Address: Ingfield Barn Inghead lane Thurstonland Huddersfield

Application number: 2026/92523	
What is the application for?:	Permission in principle for erection of one dwelling
Address of the site or building:	land off, Ing Head Lane, Thurstonland, Huddersfield, HD4 6XG
Postcode:

Drawing Title.
**SITE / LOCATION
PLANS AS PROPOSED**

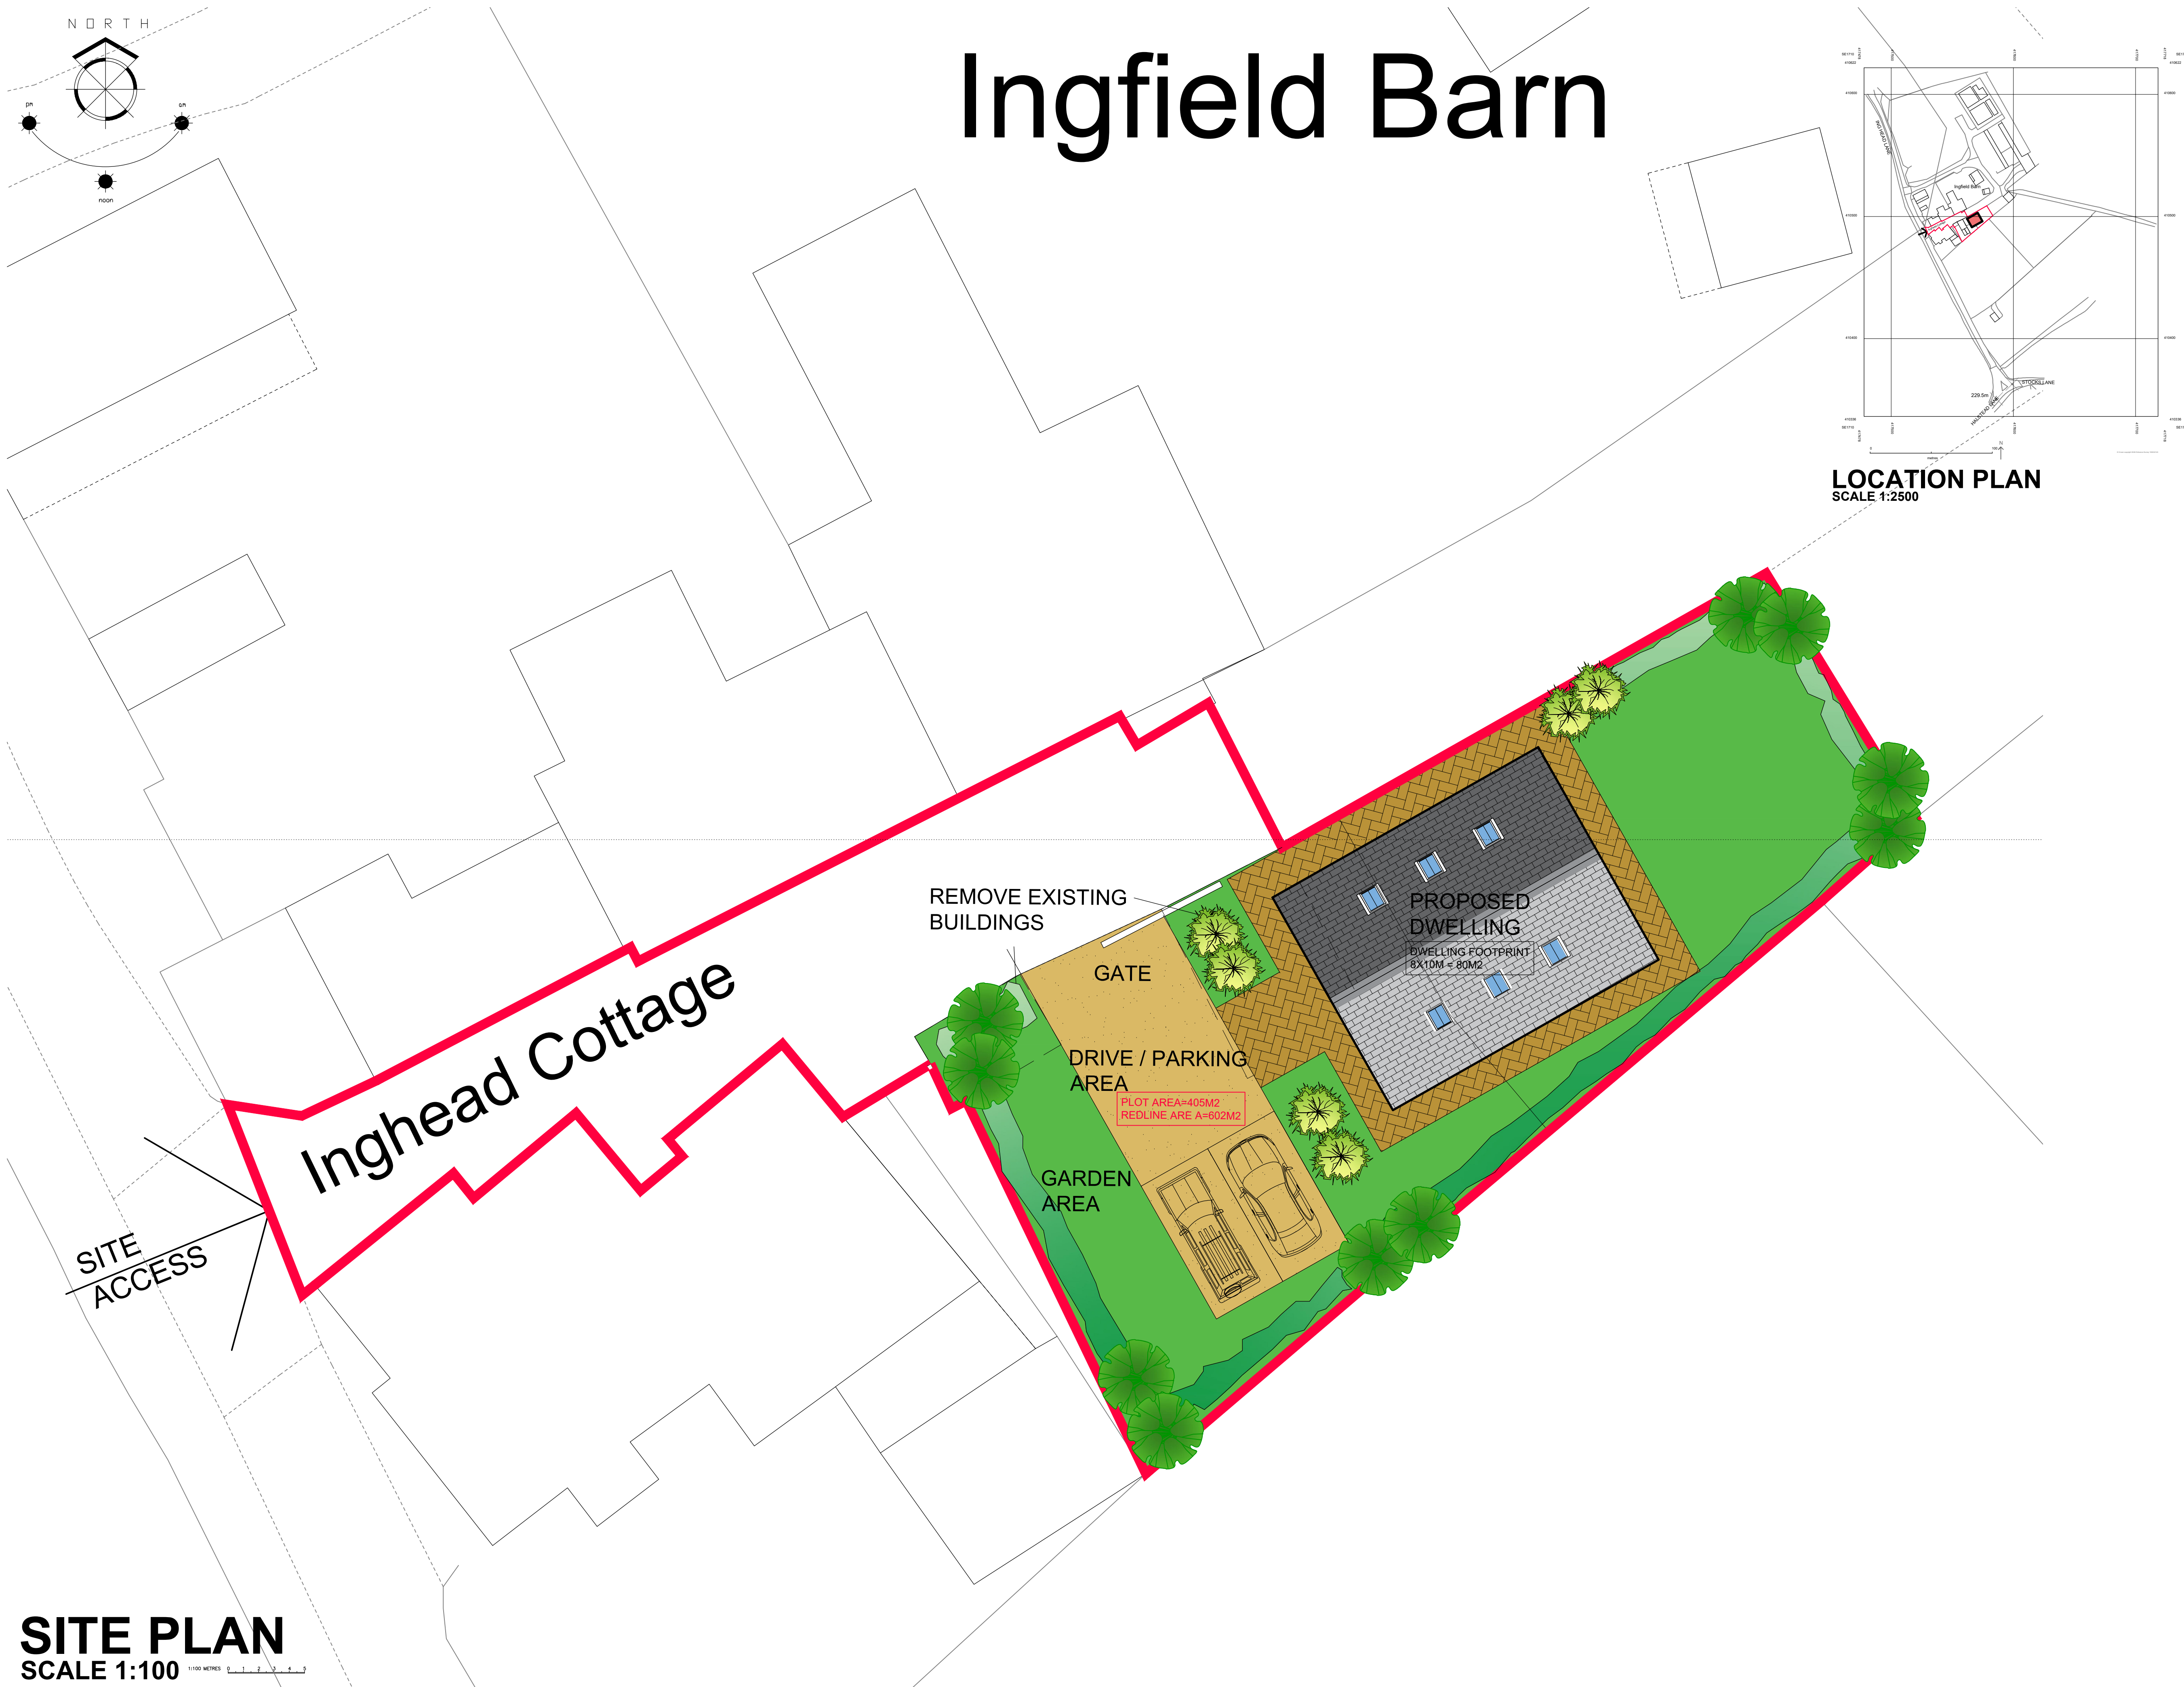
Type of comment: An objection	
Do you wish your comments to be published on the website anonymously?	No
<p>We are writing to oppose the above planning application. We have lived here for eight years and the people who we bought the house from lived here for thirty five years. At no time has there been any vehicular access from Inghead Lane. It is private land with a public footpath running from top to bottom of it. There are currently seven house doors opening directly onto the lane. The lane is only a lane as we fenced it off as we have dogs, prior to that it was open land ie: the garden.</p> <p>The refuse wagon cannot fit between the buildings at the top of the lane so where will the construction vehicles enter the site?</p> <p>There isn't any mains drainage, where will the septic tank be sited and where will the soak away be?</p> <p>The building would be directly overlooking neighbouring properties making the area oppressive, dark and overbearing spoiling a green belt area.</p> <p>I would strongly suggest a site visit to see if the small area can accommodate a house, access, parking, outdoor space and a septic tank.</p>
